WELWYN HATFIELD COUNCIL – DEVELOPMENT CONTROL
DELEGATED REPORT

APPLICATION No:	S6/2010/0342/FP
------------------------	------------------------

The existing annex would be demolished and a new structure would be built on a similar footprint. The proposal would measure approximately 7.2m in width by 10.4m in depth with a ridged roof to a maximum height of 6.2m.

Ground Floor Plan 1:100

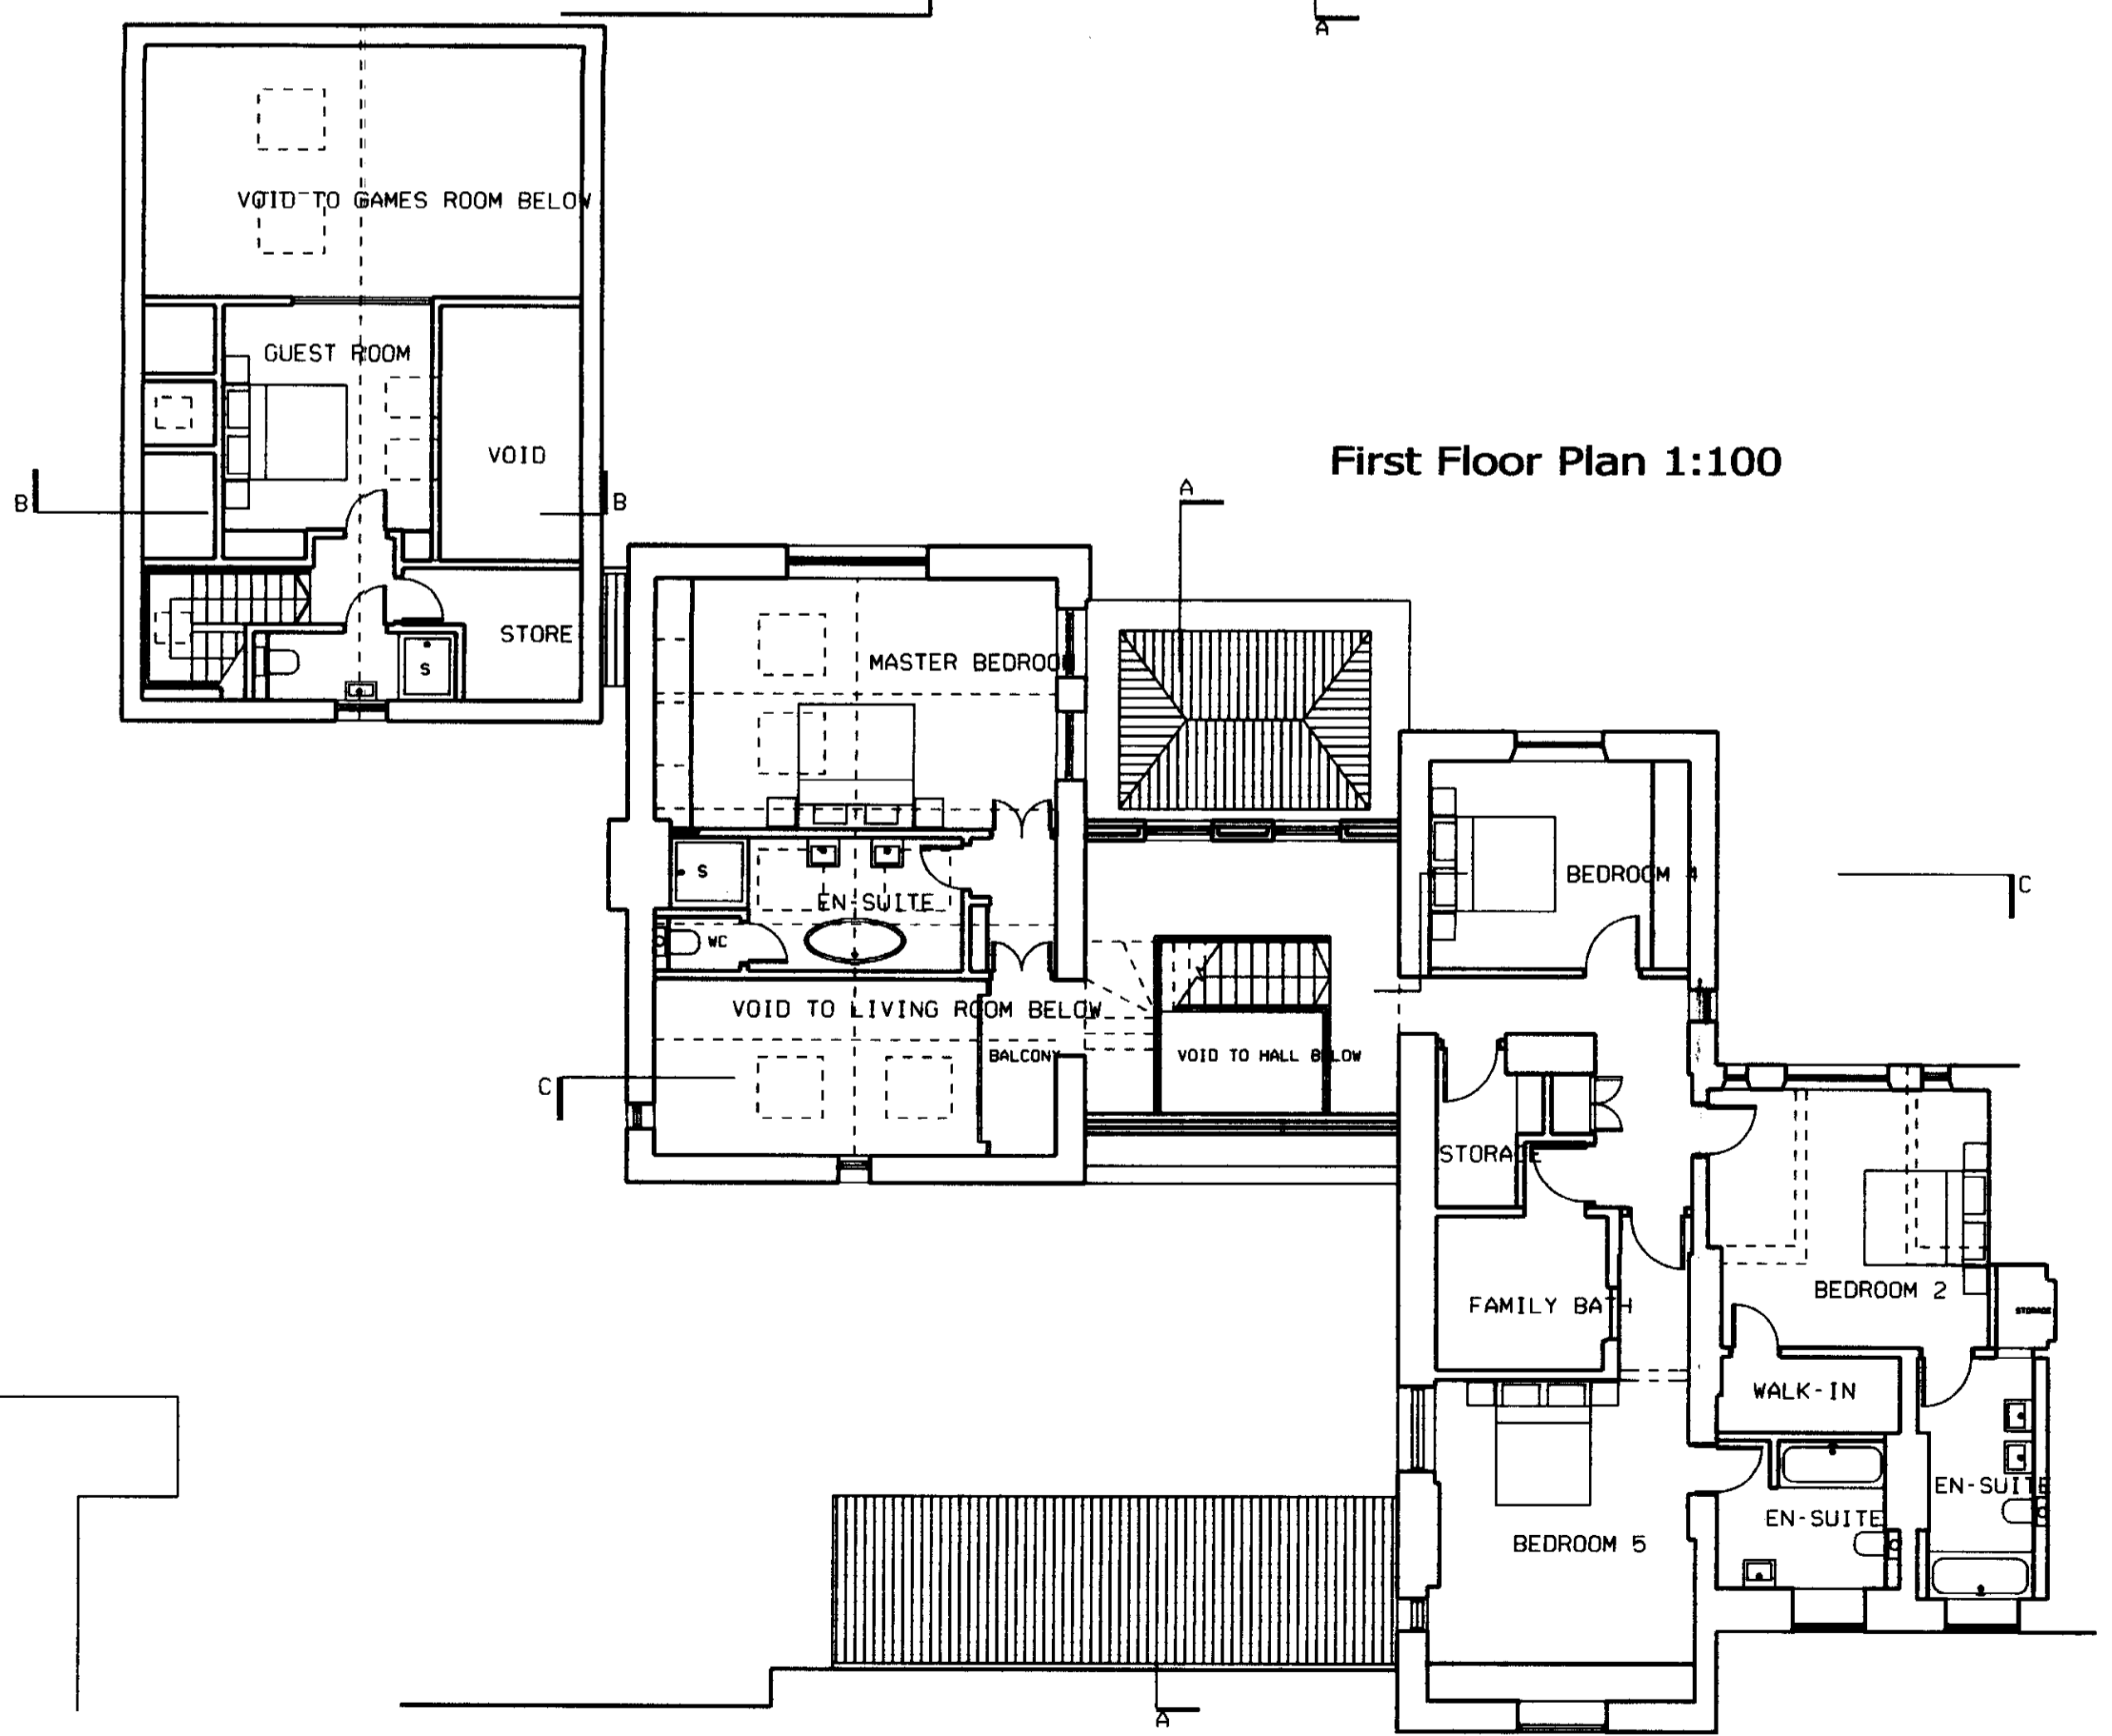
If the building is located as per drawing 0812/01 and the foundation is piled, as per the e-mail below, this would fulfil the current recommendations for building near trees.

- any indication on where the replacement oak will go
- any indication as to where the protective fencing will go
- any indication as to what working zone will be required around the building and what method of protection the ground will have which is part of the Root Protection Area but exterior to the fenced off area

The proposed development would be mostly built on the footprint of the existing annex. However, the proposal would be partially built closer to a large mature oak tree. As the existing annex may have relatively modest foundations that the adjacent trees have grown to accommodate, the potential impact of new foundations has been investigated within the arboricultural implications assessment that has been submitted.

1. C.2.1: Standard Time Limit
2. C.13.1: Development in accordance with approved plans/details 0812/01 REV.D & 0812/02 REV.D received and dated 03 March 2010.
3. C.5.2: Materials to Match
4. Foundations of the proposed development shall match the details submitted and assessed within the Arboricultural Impact and Method Statement by Henry Girling received and dated 03 March 2010.
